**HYDROLOGY DEVELOPMENT SECTION
DEVELOPMENT REVIEW BOARD MEMO**

DRB PROJECT NO: 1009178

Preliminary Plat approval

RE: Lots 6 & 31, Block 9, Volcano Cliffs Unit 18

**PLAT FOR
TIBURON HEIGHTS
WITHIN
SECTION 22,
TOWNSHIP 11 NORTH, RANGE 2 EAST, NMPM
CITY OF ALBUQUERQUE
BERNALILLO COUNTY, NEW MEXICO
SEPTEMBER, 2014**

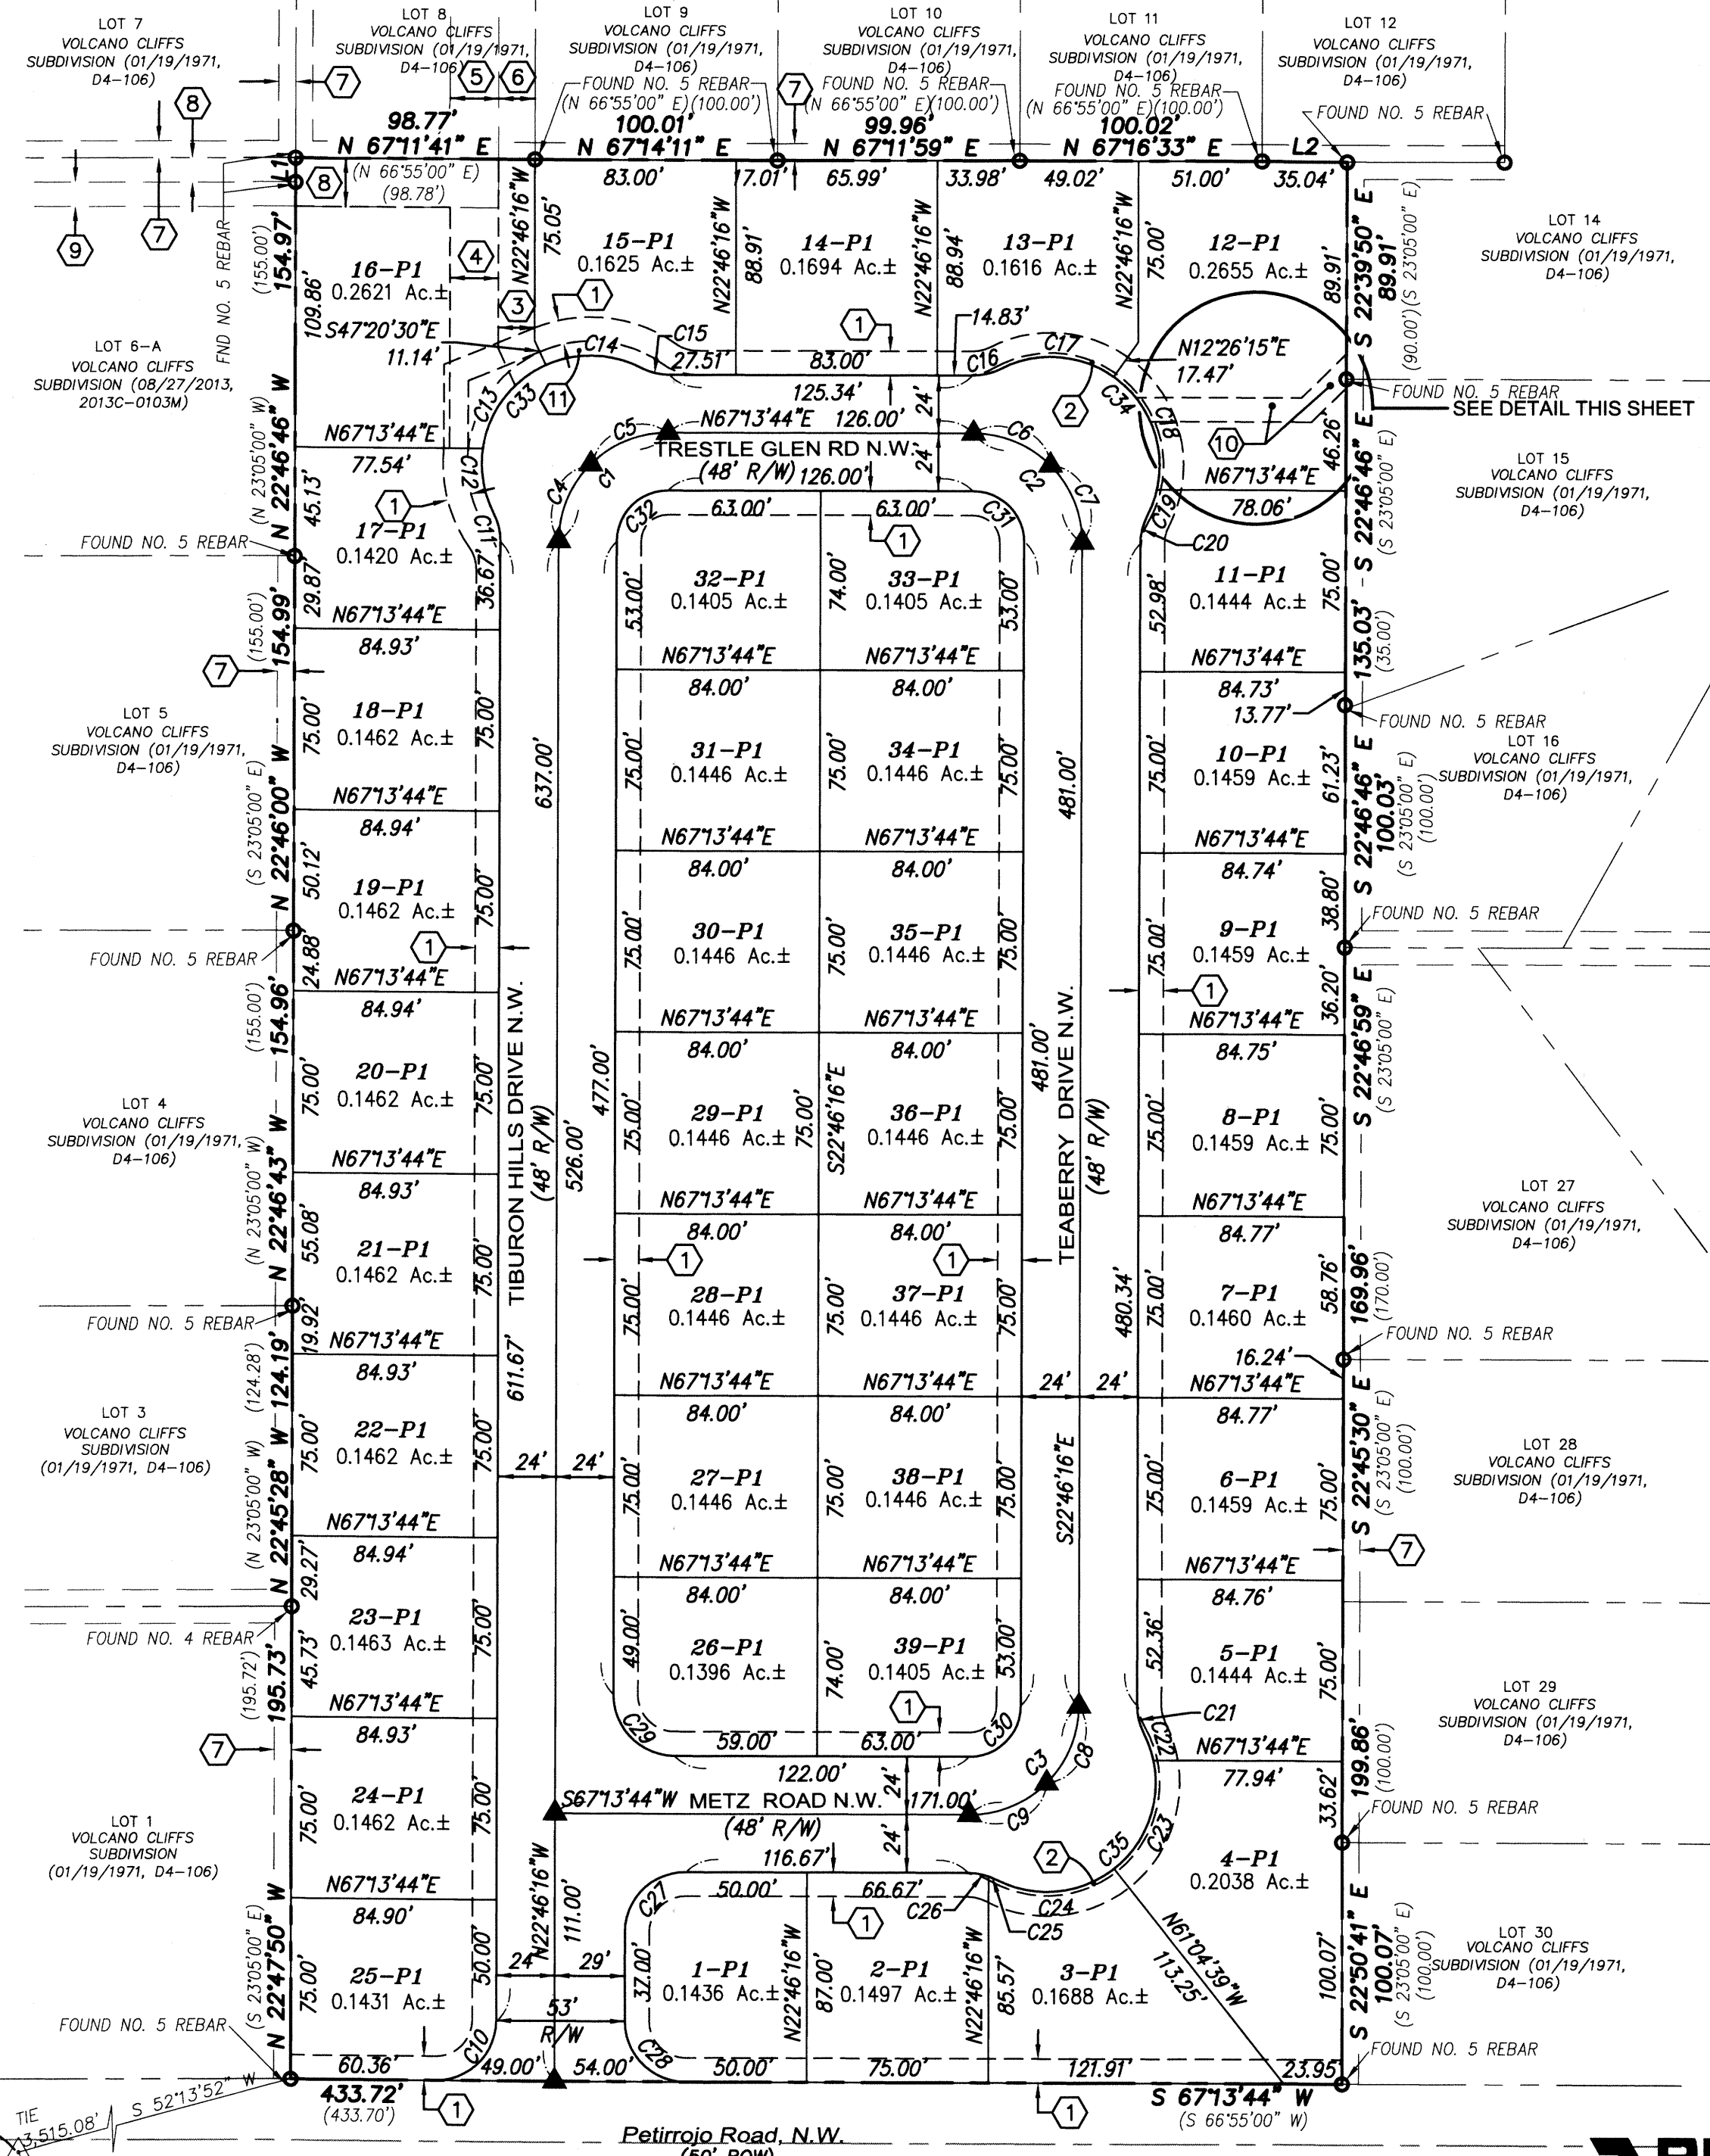
1. Please add the width of new easement number 8.
2. Proposed easement number 10 does not appear to align with the proposed storm drain in the drainage report. However, This offsite drainage solution may change.

Adequate storm drain easements are required.

SKETCH PLAT
TIBURON HEIGHTS
 WITHIN THE
 CITY OF ALBUQUERQUE
 BERNALILLO COUNTY, NEW MEXICO
 OCTOBER, 2012

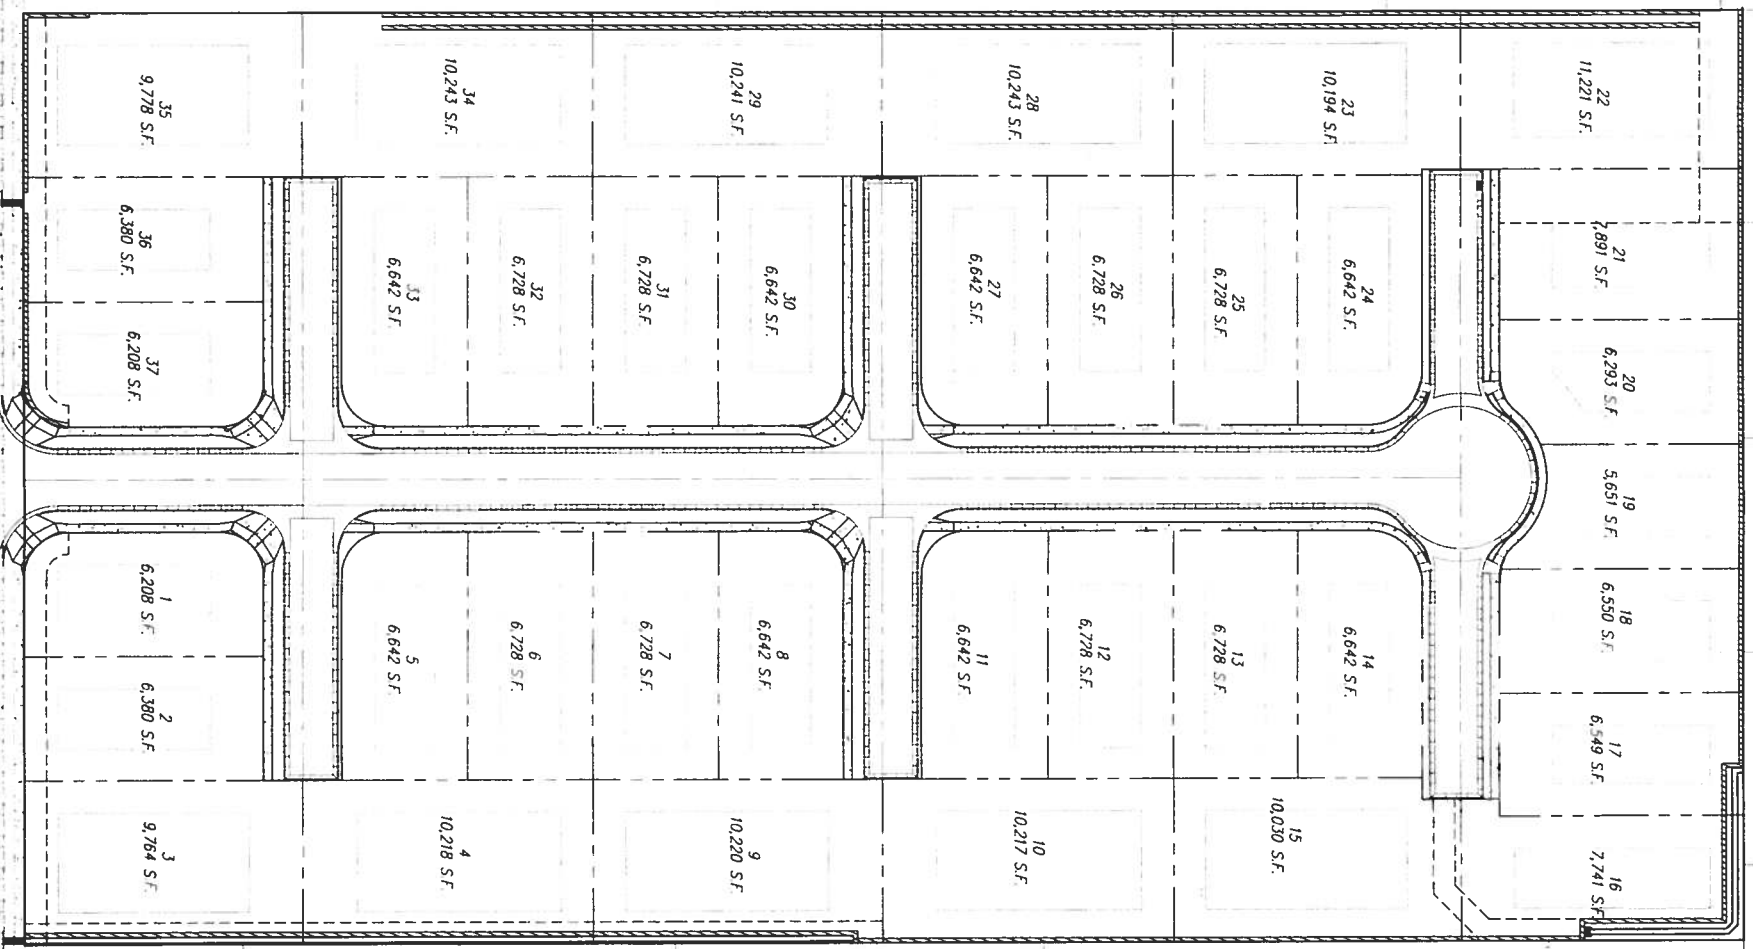
Sketch Layout: Please refer to Chapter 3 of the Volcano Cliffs Sector Development Plan. The current layout does not comply with the criteria defined within this sector plan.

Sketch Layout: Please refer to Chapter 3 of the Volcano Cliffs Sector Development Plan. The current layout does not comply with the criteria defined within this sector plan.
